**An
Bord
Pleanála**

Memorandum ACP-323024-25 – Request for Further Information

To: Stephen Rhys Thomas, ADP
From: Peadar McQuaid, PI
Re: 323024-25
Date: 27th March 2026

ENVIRONMENTAL: SAC EXTENTS
PROPOSED TYPICAL ROAD RAISING CROSS SECTION A-A
SCALE 1:100

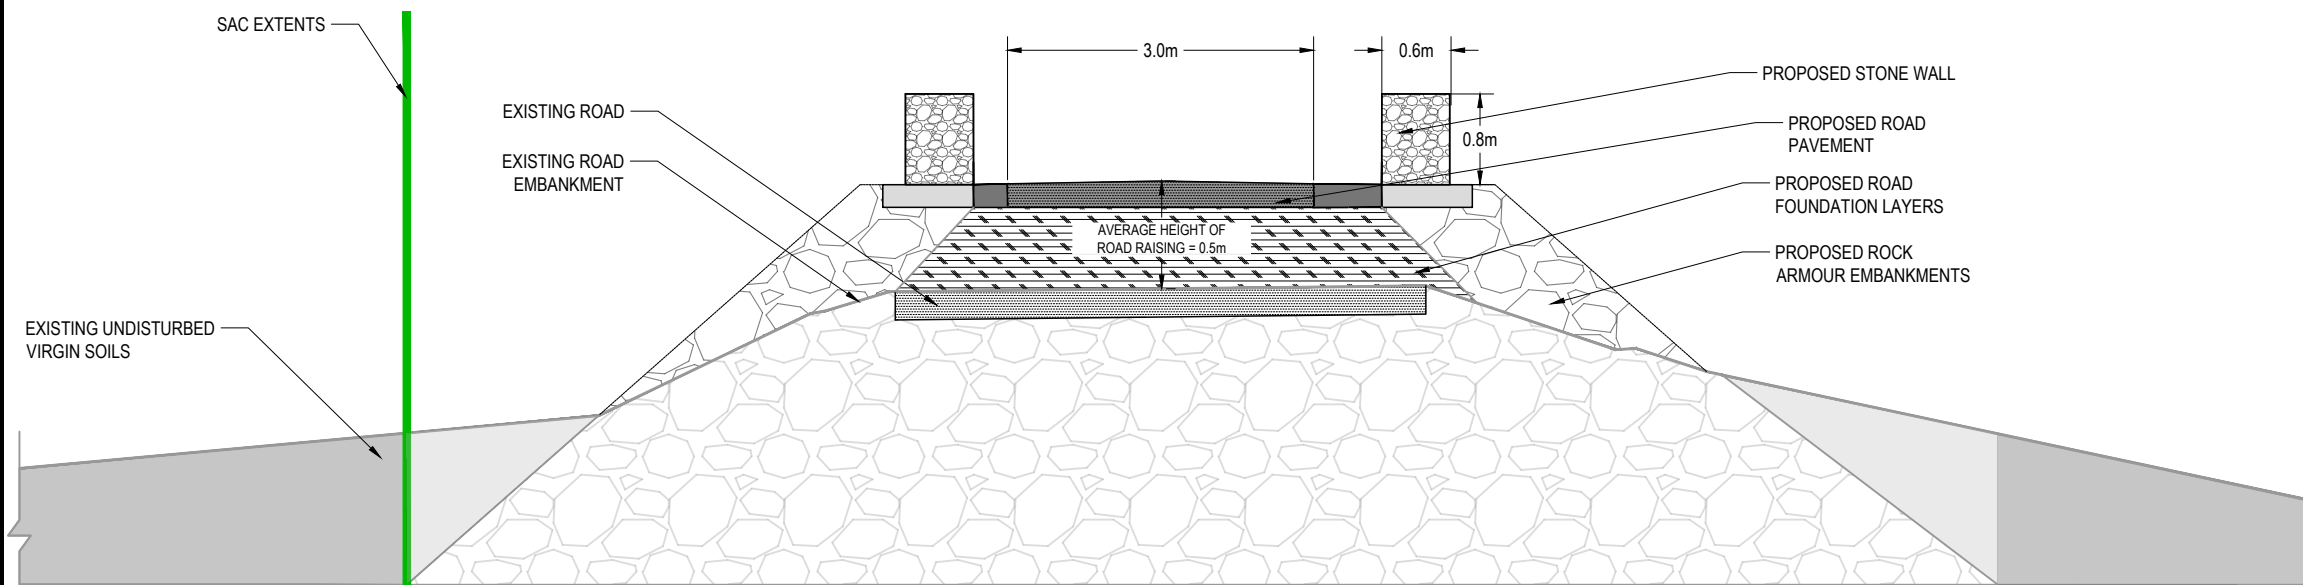
The width of the carriageway has increased slightly by 0.3m from 2.7m to 3.0m as shown on drawing reference number 1202 however I do not consider this a significant amendment.
